This letter delivers the results of Office of Environment and Heritage's (OEH) assessment of the biodiversity and Aboriginal Cultural Heritage impacts associated with Yass Valley Wind Farm, project reference MP08_0246.

Attachment 1: OEH's Assessment of the Biodiversity and Aboriginal Cultural Heritage Impacts Associated with Yass Wind Farm May 2014

TITLE
 EA & PPR
 Turbine Layout
 Comparison

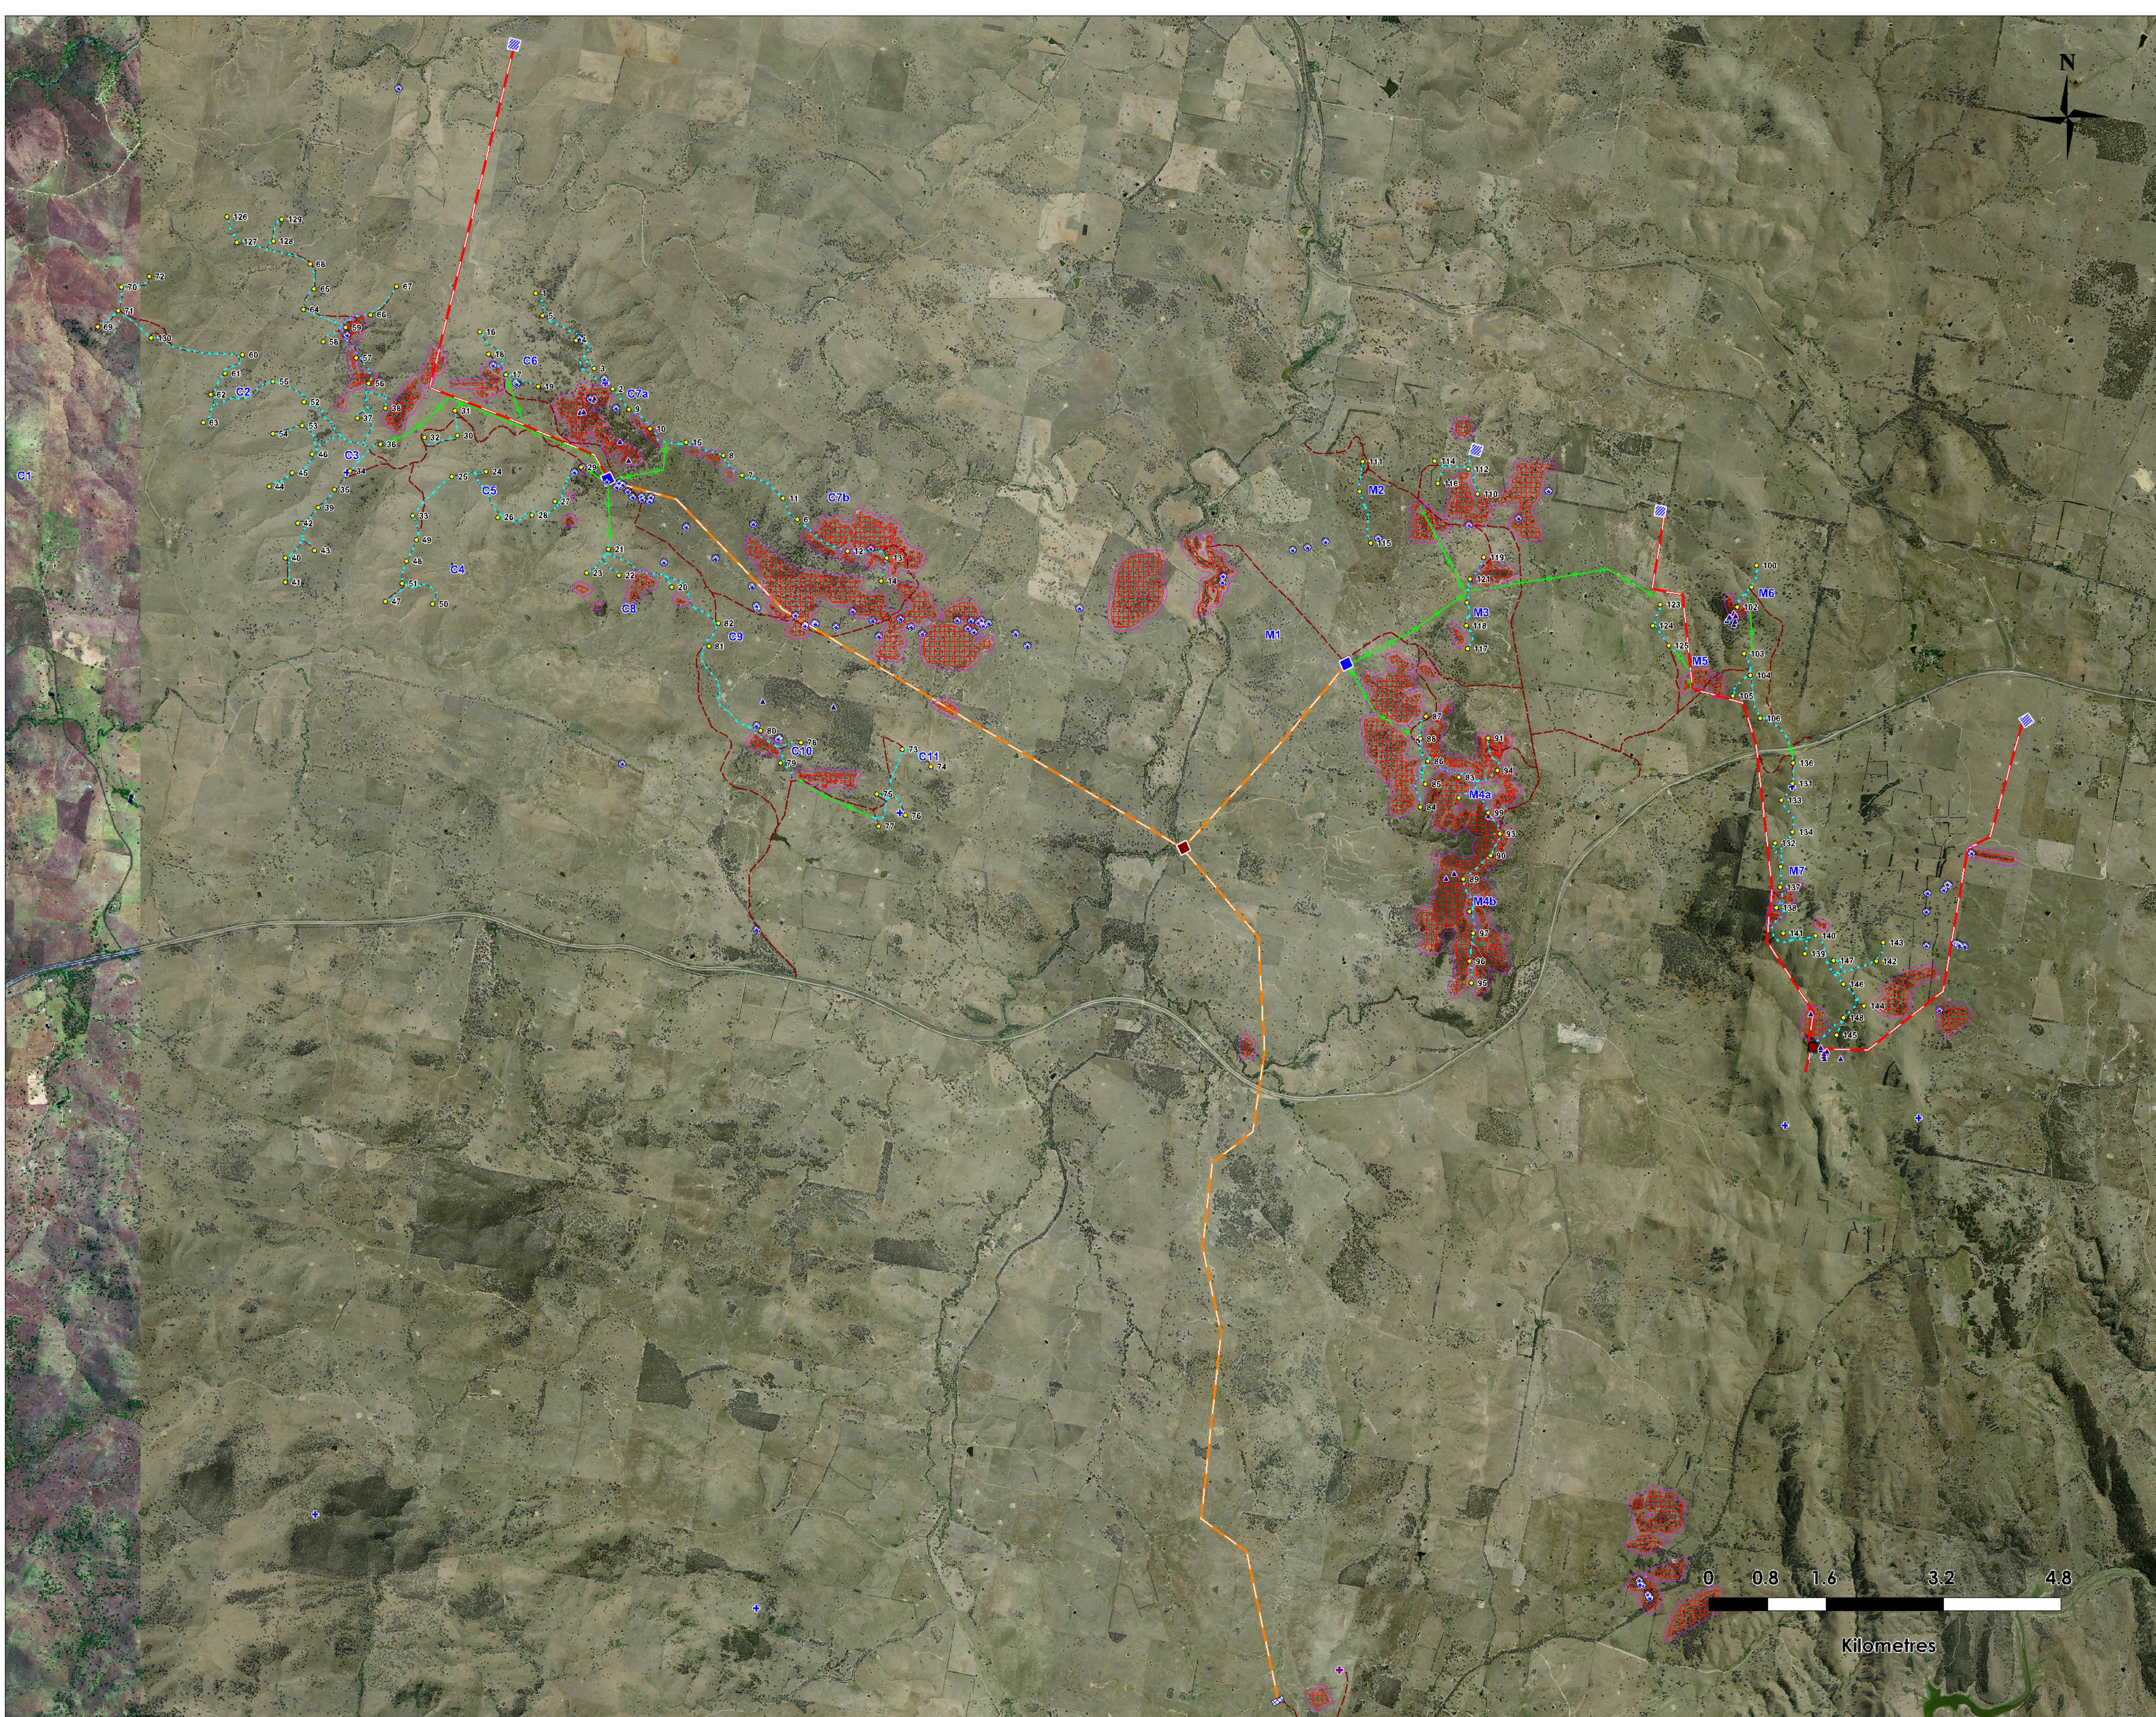
This is in response to OEH's enquiry about why there are numerous turbine locations where the reticulation lines do not lead to the turbine location. The explanation covers most of the turbine locations assessed, except for turbine 100 which is over 65m beyond the end of the reticulation lines (see figure below).

TITLE
Biodiversity
High constraint areas

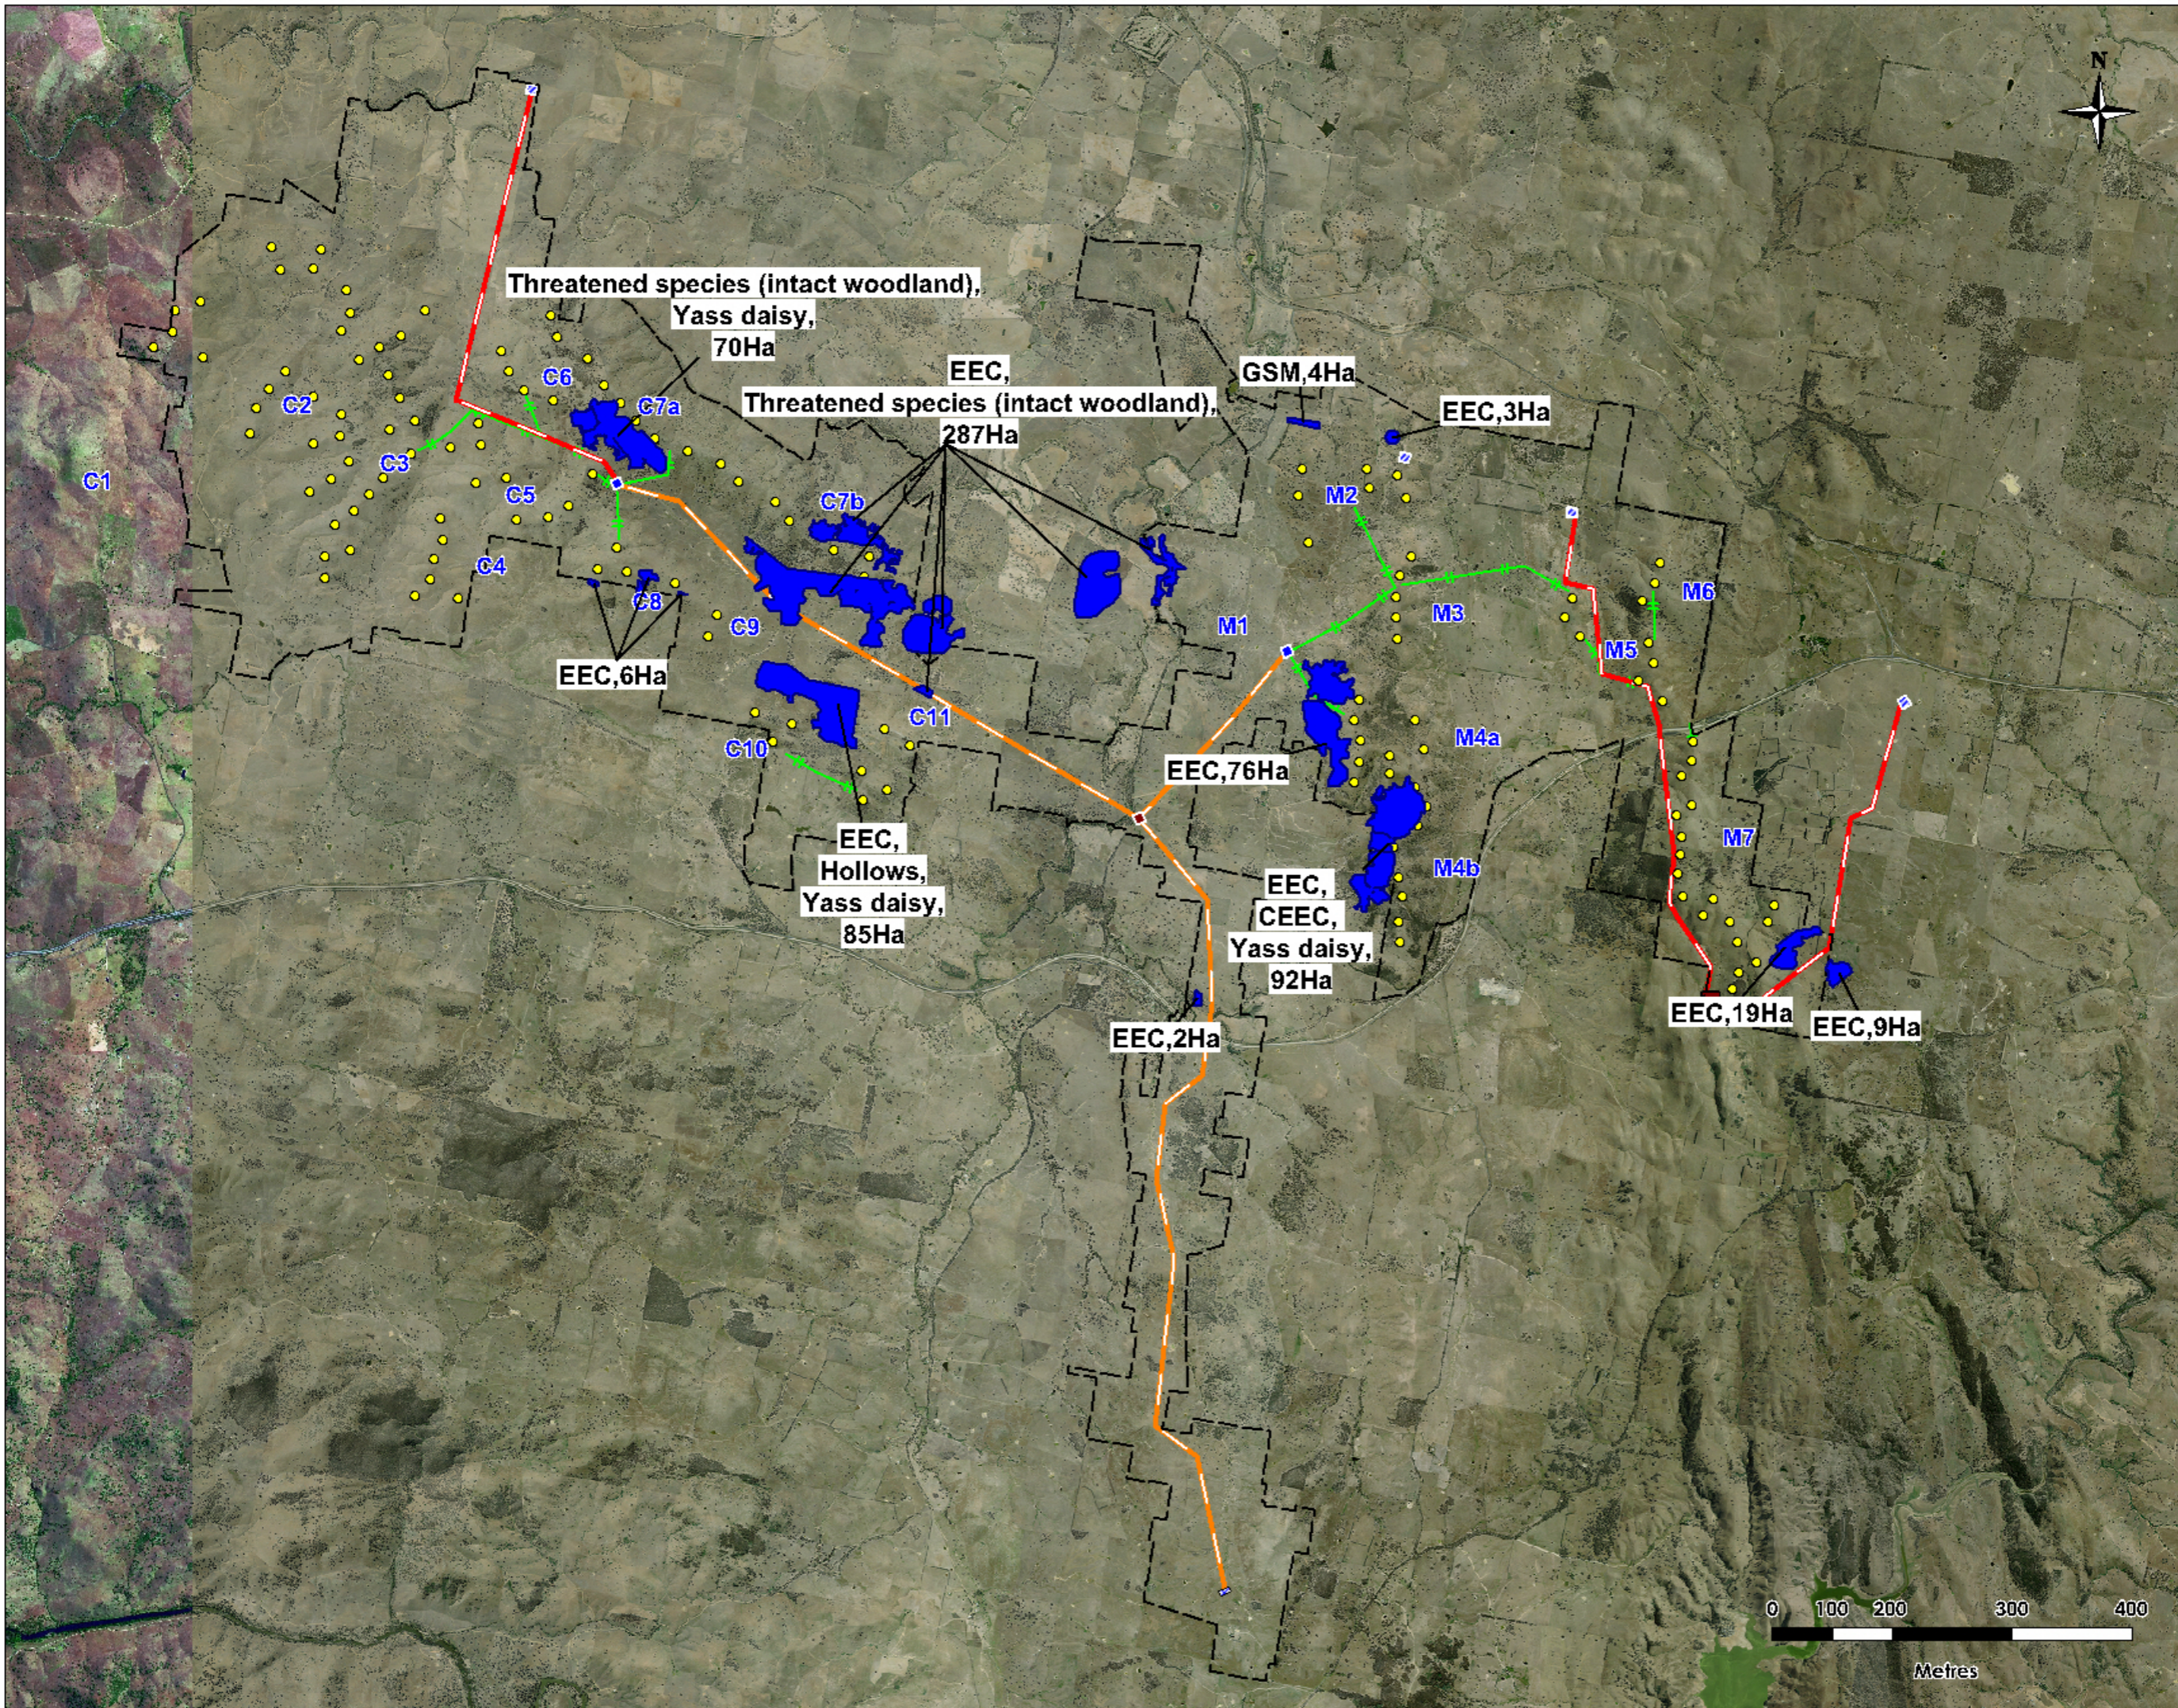
In OEH's letter dated 24 February 2014, we raised the matter that there were a number of inconsistencies with the high constraint layer and that it was not clear why certain areas were of high, medium, low constraint, or not ranked. There were a large number of turbines (nearly 45%) where the constraint level had not been mapped around them.

OEH has reviewed this layer and does not consider that the current high constraint layer is a complete reflection of the environmental values across the site. It does provide some guidance about some constraints and will hopefully result in the avoidance of some areas but it is not wholly reliable. There is still one turbine (#138) that is within a high constraint area and there are a number of other turbines within 50m of high constraint areas. There are multiple access tracks and electrical reticulation lines that also pass through high constraint areas.

OEH contends that placing turbines within close proximity of woodland areas is likely to quarantine the value of that habitat for many species. As previously recommended to the proponents, OEH considers that it is best practice to implement a buffer between the turbines and woodland areas in line with the distance adopted by the University of Bristol and the Bat Conservation Trust (2009) – Diagram sent to DPE and Epuron in February 2014.
